WELWYN HATFIELD BOROUGH COUNCIL – DEVELOPMENT MANAGEMENT
DELEGATED REPORT

APPLICATION No: S6/2014/0008/FP

SITE ADDRESS: 127 THE RIDGEWAY, CUFFLEY

**DESCRIPTION OF DEVELOPMENT: PROPOSED ERECTION OF REAR
EXTENSION AT GROUND AND FIRST FLOOR LEVELS**

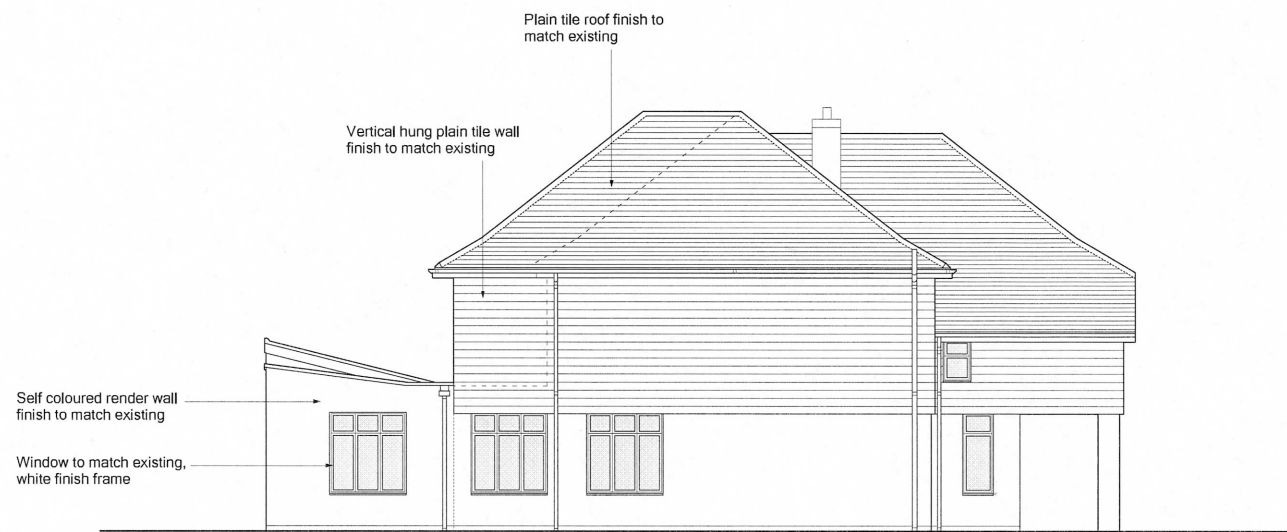
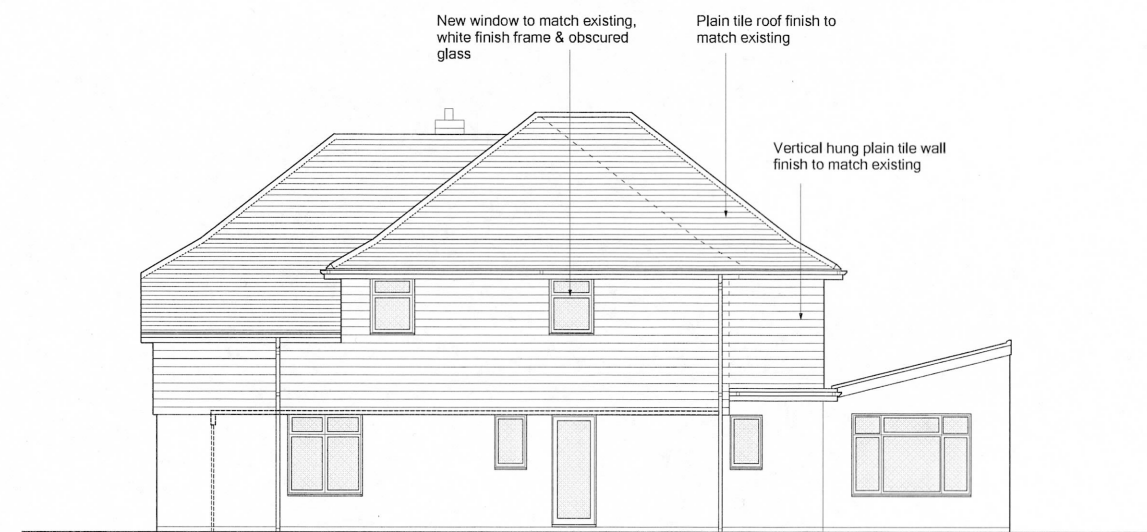
The character of the streetscene will be affected by the extensions to the rear of the dwelling. No.125 The Ridgeway is set back from the highway which makes No.127 more prominent within the streetscene, therefore by extending the rear of the dwelling at first floor level it would create a subordinate mass to the side elevation

and roof which will be clearly visible from the highway and affect the character of the streetscene.

The proposal will include formation of a dual pitched roof to the rear which will be incongruous and be out of character within the surrounding area. It is considered that the design would not relate well to the host dwelling and would conflict with Policies GBSP2, D1 and D2 of the adopted Welwyn Hatfield District Plan 2005 insofar as these seek to ensure that development is designed to a high quality, respects local character and context and is compatible with the character of Cuffley. The proposal also fails to comply with the National Planning Policy Framework in terms of design.
